**Application for a non-material amendment following a grant of planning permission.  
 Town and Country Planning Act 1990**

19/02112/F

Garage Conversion Floor Plan and Elevations (Version 1.1)

Garage Conversion Floor Plan and Elevations (Version 1.2)

FRONT ELEVATION

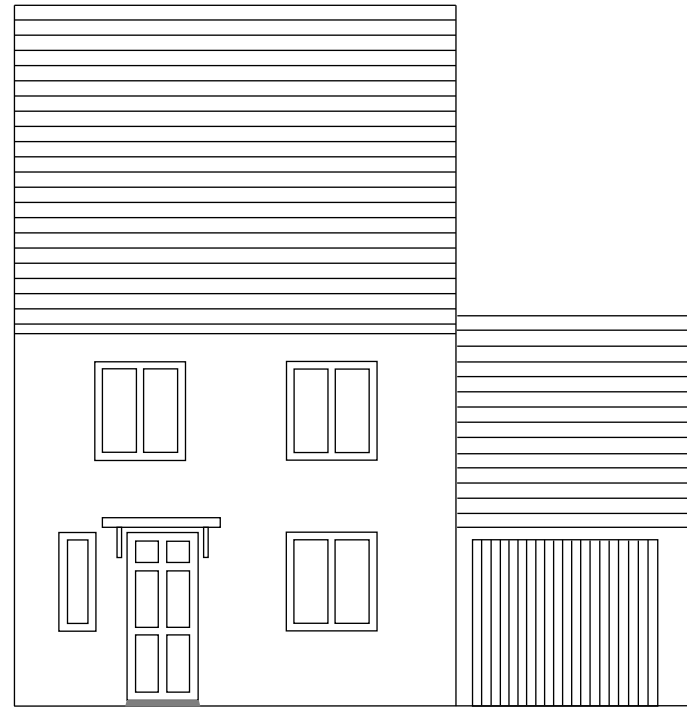
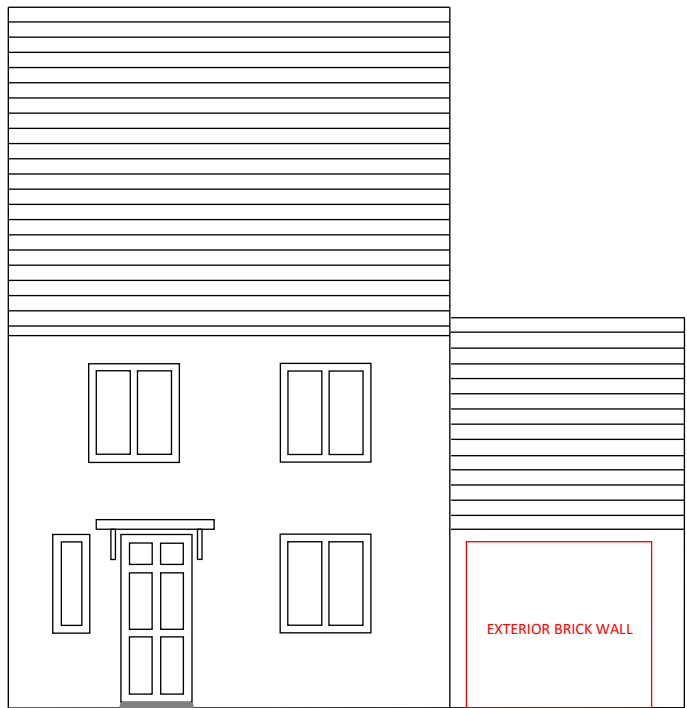
As part of the garage conversion, the existing garage door will be removed and replaced by a solid brick wall using an exact rustic red brick match to remain in keeping with the rest of the property and existing garage brickwork.

The amendment will provide a more structurally robust alternative to a partition behind the existing garage door. This amendment will also negate potential challenges that might arise around maintaining a restricted garage door (e.g. external damage and corrosion to the door, water ingress and debris issues between the garage door and partition wall). The amendment will involve construction of a solid brick wall using an exact rustic red brick match to remain in keeping with the rest of the property.
